Item No. **Report of the Head of Planning, Transportation and Regeneration**

Address 45 ETON ROAD HARLINGTON

Development: Erection of a single storey rear extension and a two storey side extension to form a separate two-bedroom dwelling.

LBH Ref Nos: **1624/APP/2021/4611**

PROPOSED GROUND FLOOR
@ 1 : 100

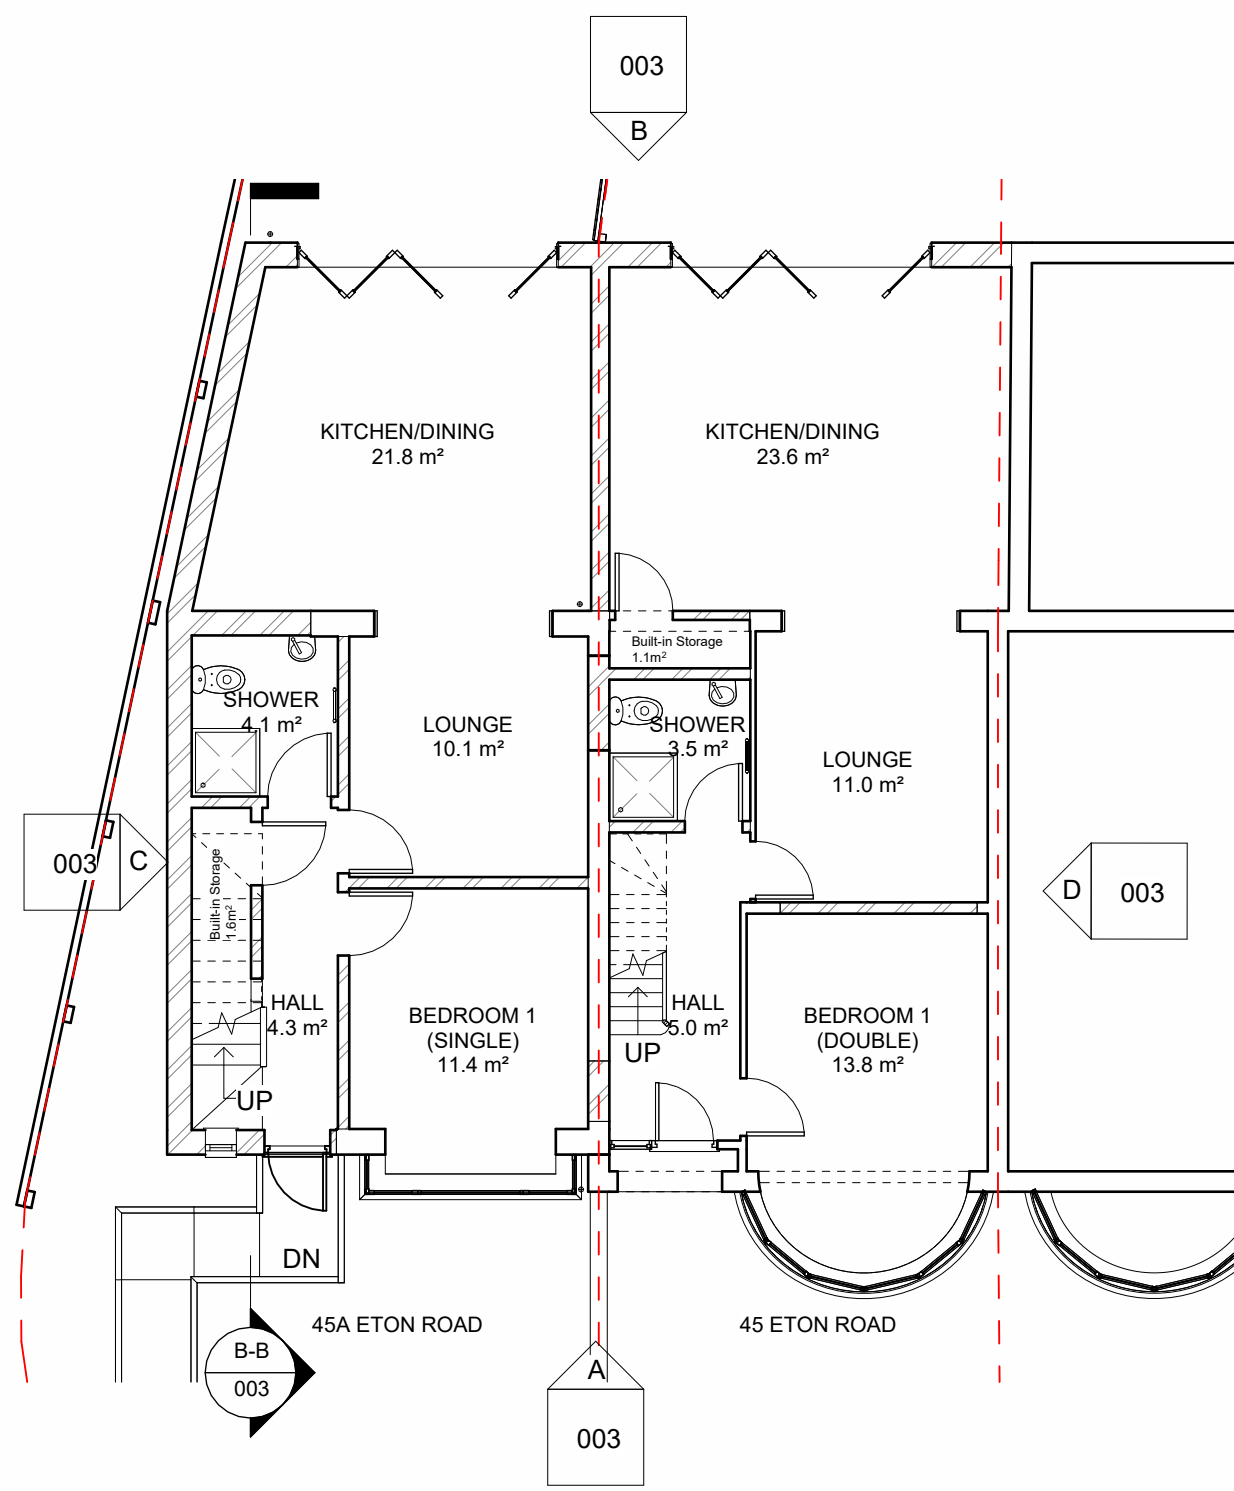
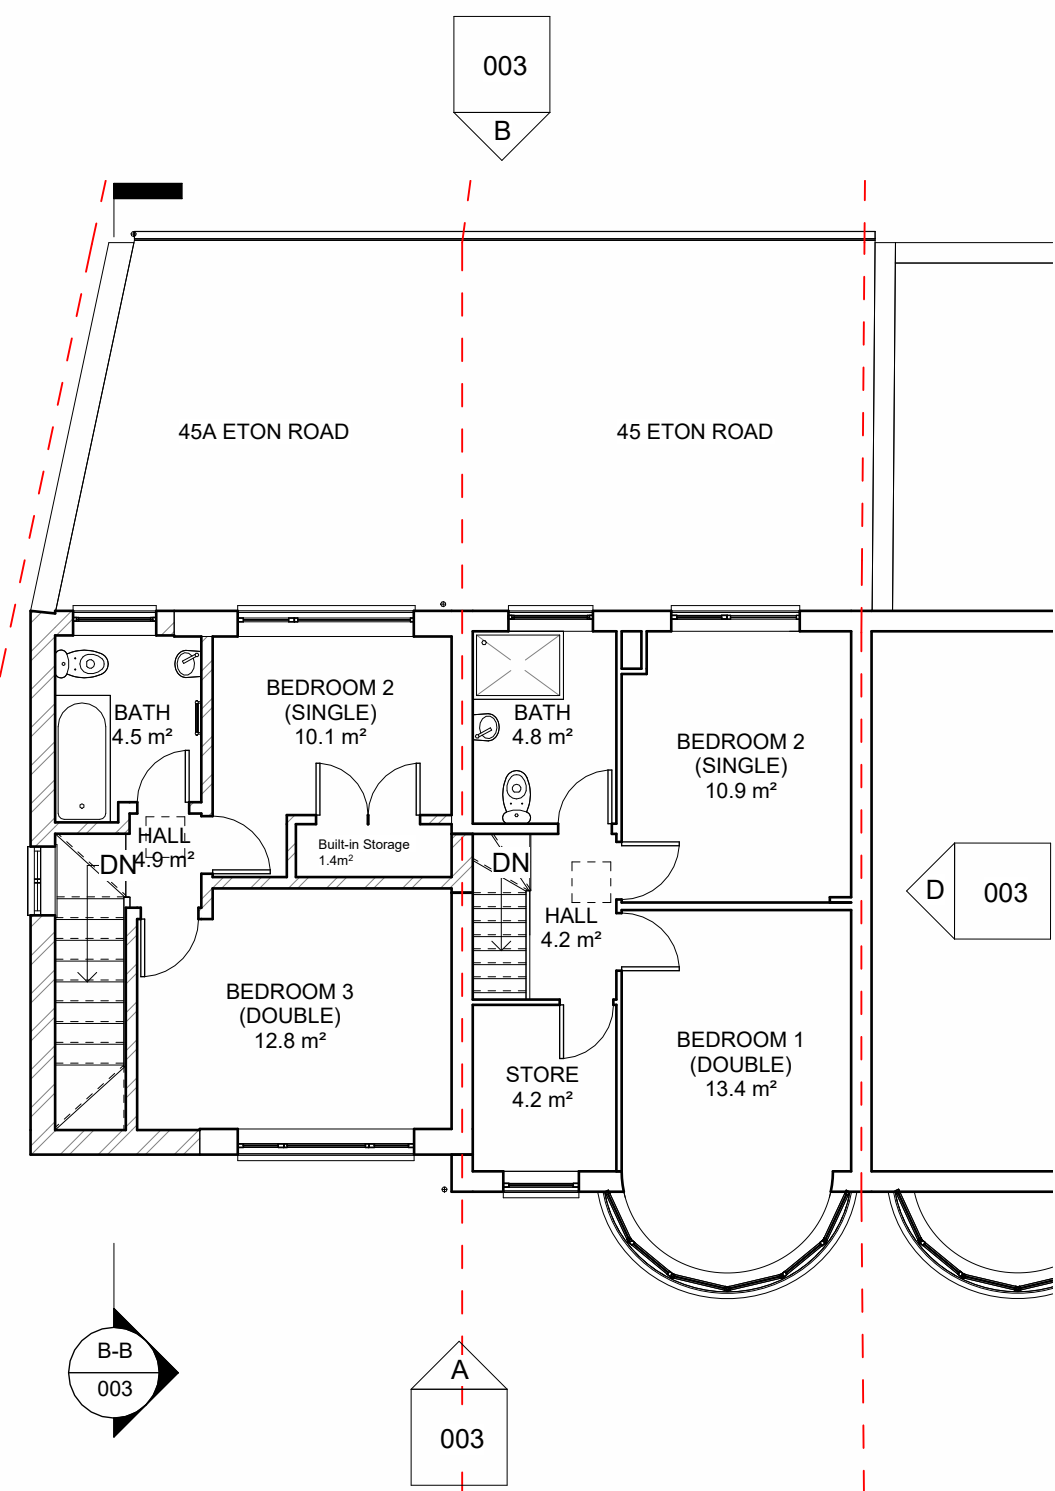
The proposed dwelling would include no double/twin bedroom with a floor space of 11.5sqm, it would therefore provide a substandard internal bedroom mix and is contrary to Policy D6 of the London Plan. There is no clear benefits to outweigh this factor in the design.

'This proposal for an extension of the existing dwelling and formation of a new three-bedroom dwelling (shown on drawing no. 003) raises the following accessibility concerns. The 2021 London Plan and its contained policy D7 requires all new housing, as a minimum standard, to be designed and constructed as accessible and adaptable in accordance with M4(2) as set out in Approved Document M to the Building Regulations (2015 edition). 1. Step free access via the principal private entrance, and all other points of entry and exit, have not been shown on plan. 2. The entrance level W/C is too small, does not achieve the required clear access zones or otherwise meet the provisions set out in section 2.27(c) of Approved Document M, Volume 1 (2015 edition). 3. Plans should be submitted to demonstrate compliance with the spatial requirements within the bedrooms, bathrooms and kitchen areas. The floor plans should illustrate the requisite clear access zones in context to typical furniture items within the said rooms. 4. The plans need to be amended to align with all other M4(2) technical specifications (as relevant), set out in Approved Document M to the Building Regulations (2015 edition). CONCLUSION: unacceptable.'

PROPOSED SITE LAYOUT PLAN
@ 1 : 200

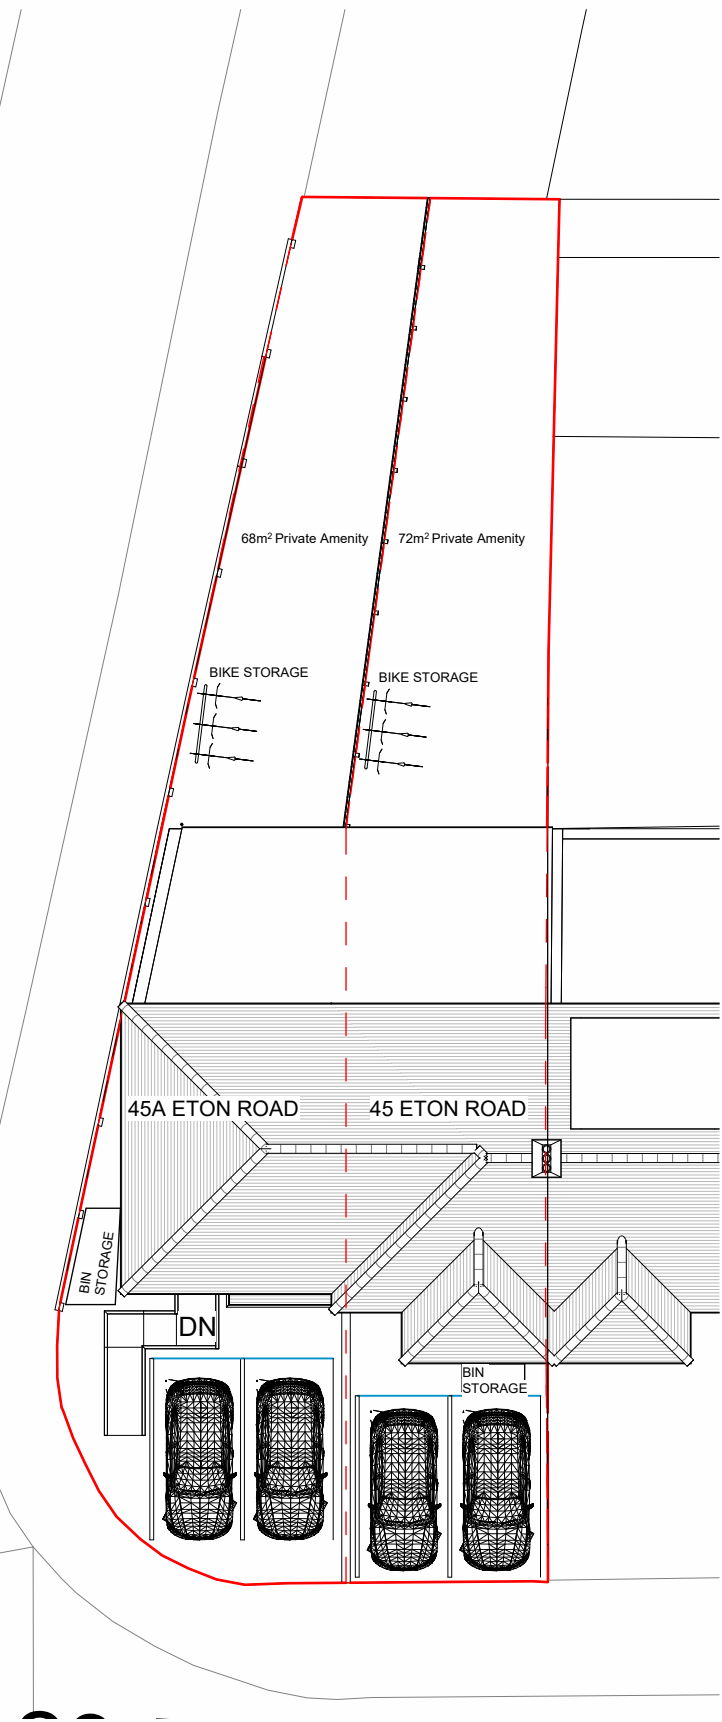
The proposed fully hard landscaped garden (spanning across the width of both dwellings) would be harmful to the appearance of the street scene, where frontages generally have more greenery and soft landscaping.

The London Plan (2021) advises that proposals for 3 bed dwellings, in outer London, with the mentioned PTAL rating should provide up to 1 parking space. It is therefore considered that 1 space should be provided for the new dwelling. 2 are proposed and therefore there is an over provision of 1 space.

Taking into consideration that a condition could be placed on the application requiring a revised parking plan (removing 1 parking space), visibility splays, ev charging points could also be required, It is considered that adequate and safe parking for 1 car could be provided on site for the new dwelling. There is nothing in the Local Plan (2012 or 2020) or London Plan (2021) or NPPF (2021) which states that in opportunity areas, minor development comprising one residential unit in PTAL 2, should be completely car free.

JOB NO. PROJ/2420 **DRAWING NO.** 003 **REV:** A

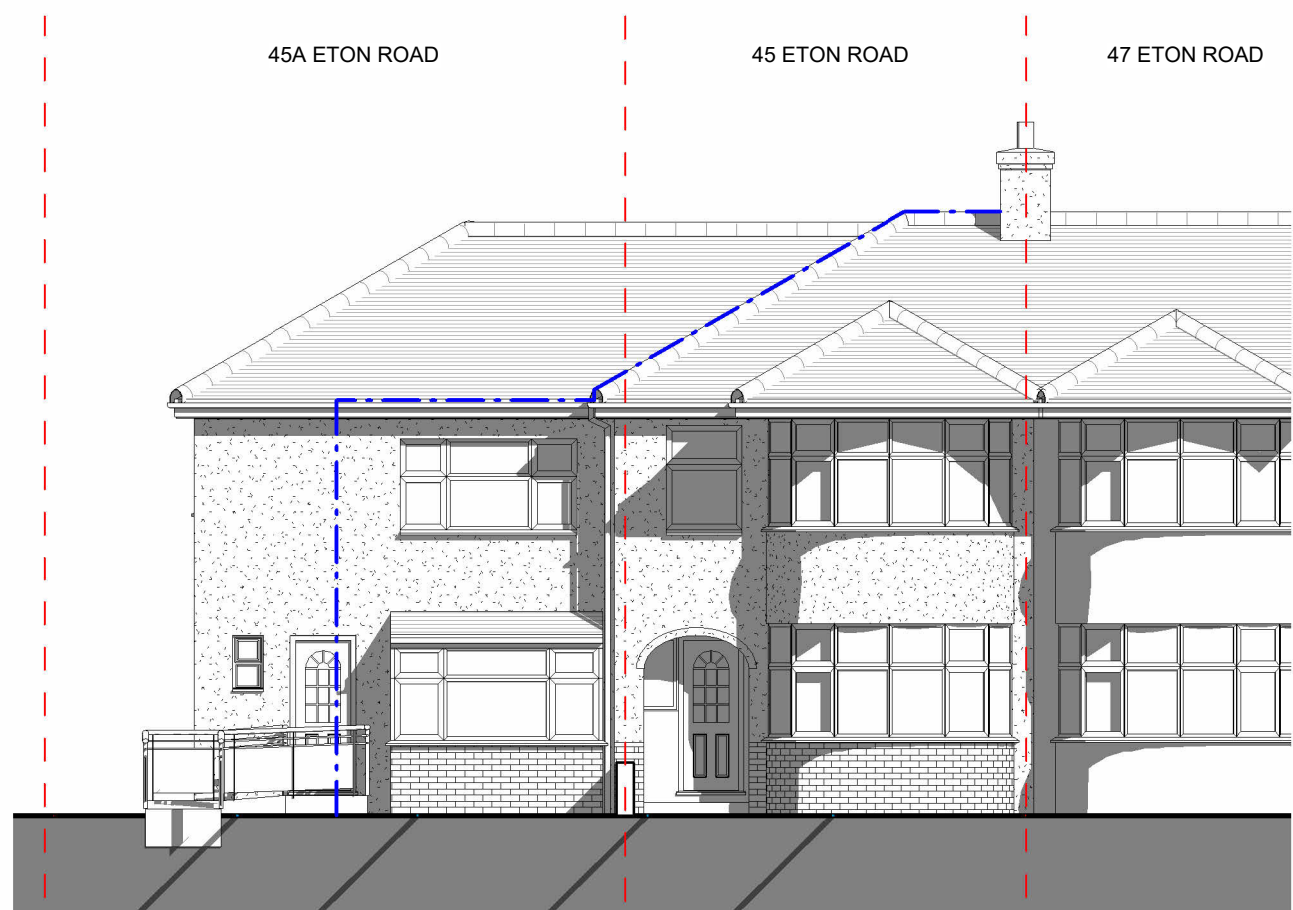
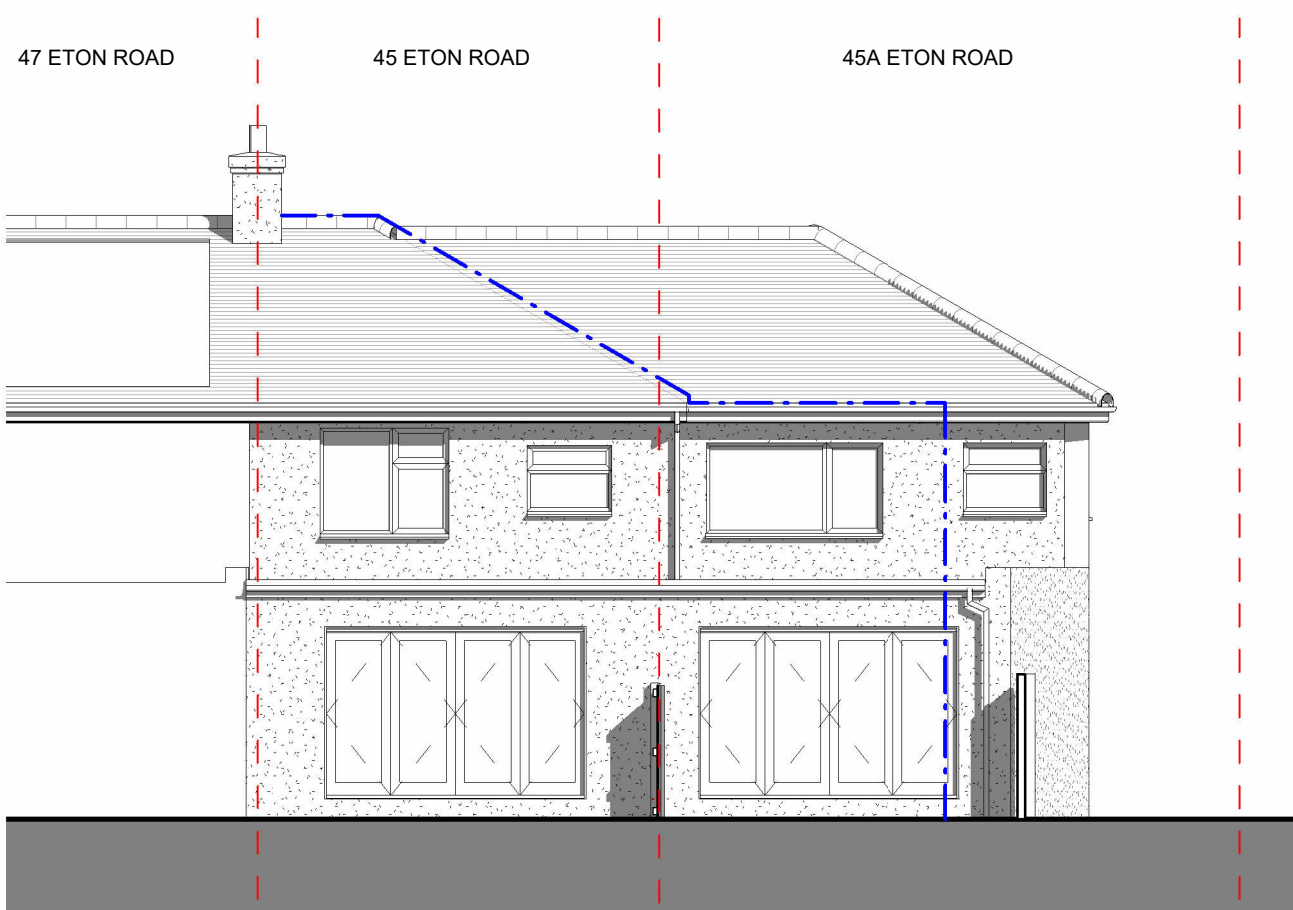
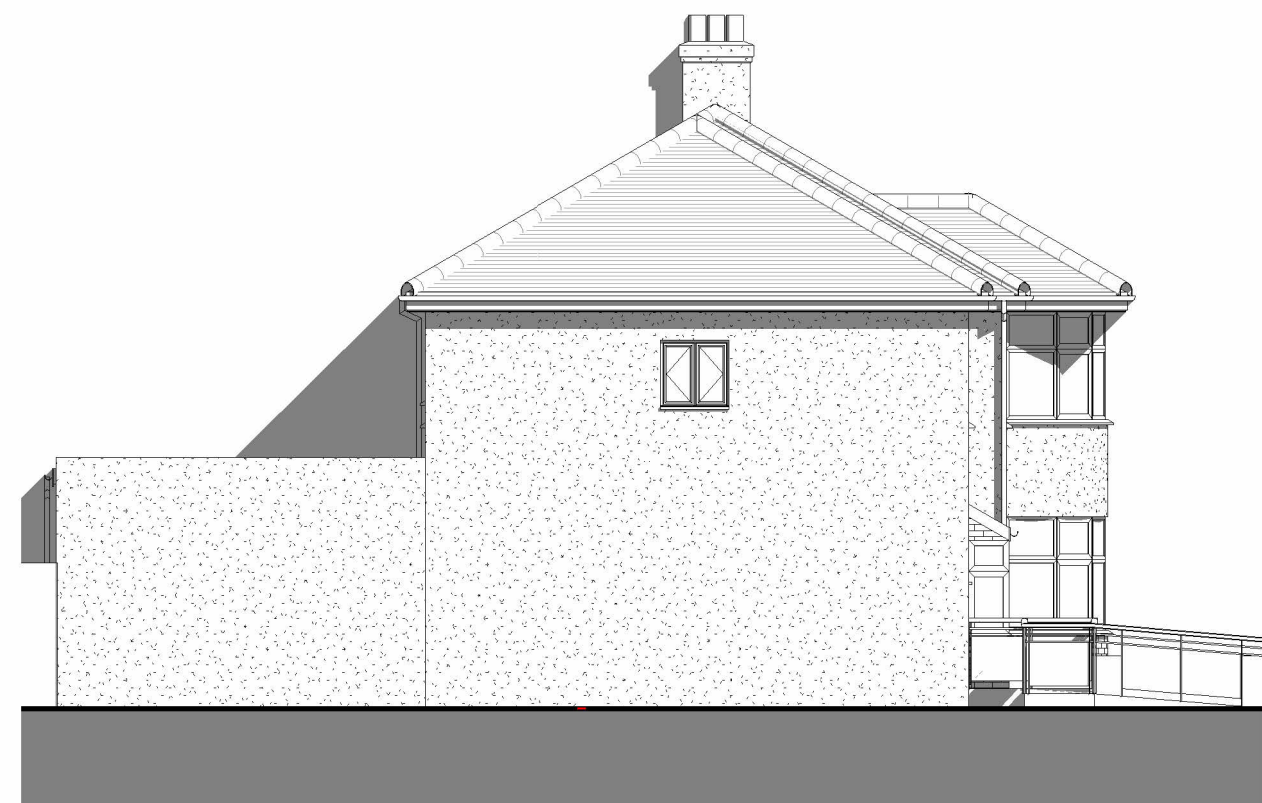
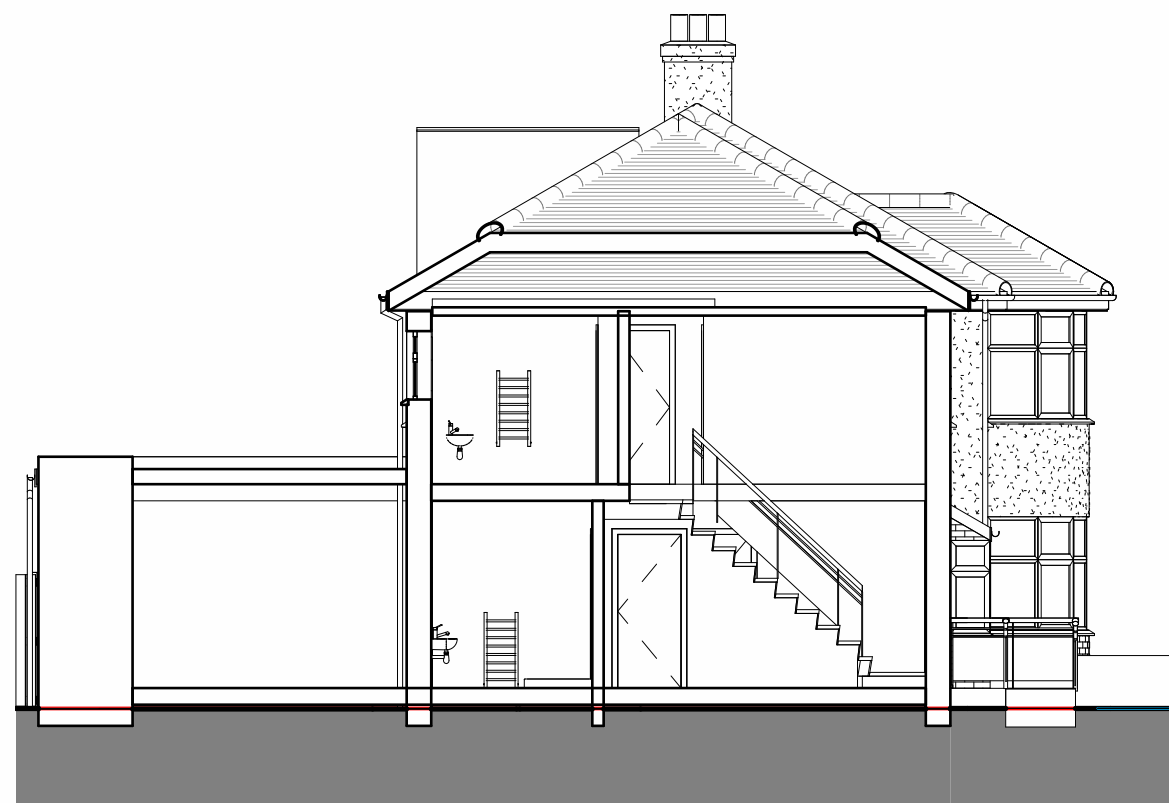
The proposal seeks to extend an existing house in order to create a new dwelling. The new dwelling would replace an existing two storey side extension. Whilst it is noted that a two storey side extension already exists at the property and is somewhat unattractive with its flat roof, the extension provides a sense of balance with the other corner property which has a similar design and treatment. This extension also retains a gap to the boundary and has a simple, fenestration treatment and detailing.

The proposed extension / new dwelling would be wider, higher and deeper. It would therefore reduce the openness of this corner plot to the detriment of the area's character and appearance. It would read as an incongruous and overly dominant anomaly with an awkward and uncharacteristic design.

The extension would result in the creation of a 3 property terrace block. The area is characterised by pairs of semi detached properties as such the resulting terrace would appear out of character amongst other properties in the area. The pair of properties would be unbalanced and the design does little to mitigate that impact with the splayed ground floor wall, excessive width and proximity to the boundary.

No. 45 Eton Road, forms one half of a pair of semi detached dwellings. Whilst it is noted that the existing property has a two storey side extension. The proposed dwelling is

significantly larger. It is wider than the property that it would be attached to. As such it is considered that the new dwelling would cause harm to the pair of semi detached dwellings, by unbalancing and disrupting their remaining visual symmetry. Symmetry between pairs of semi detached properties is a characteristic of the area which the proposal would fail to respect.

Furthermore the new dwelling would have a single first floor front elevation window, and mono pitched porch. The mentioned architectural details, whilst similar to the existing extension, would fail to compliment the design of the other properties in the resulting terrace block which have balanced fenestrations (i.e openings at ground and first floor). The design of the property would therefore cause harm to the appearance of the neighbouring properties (No's 45 and 47).
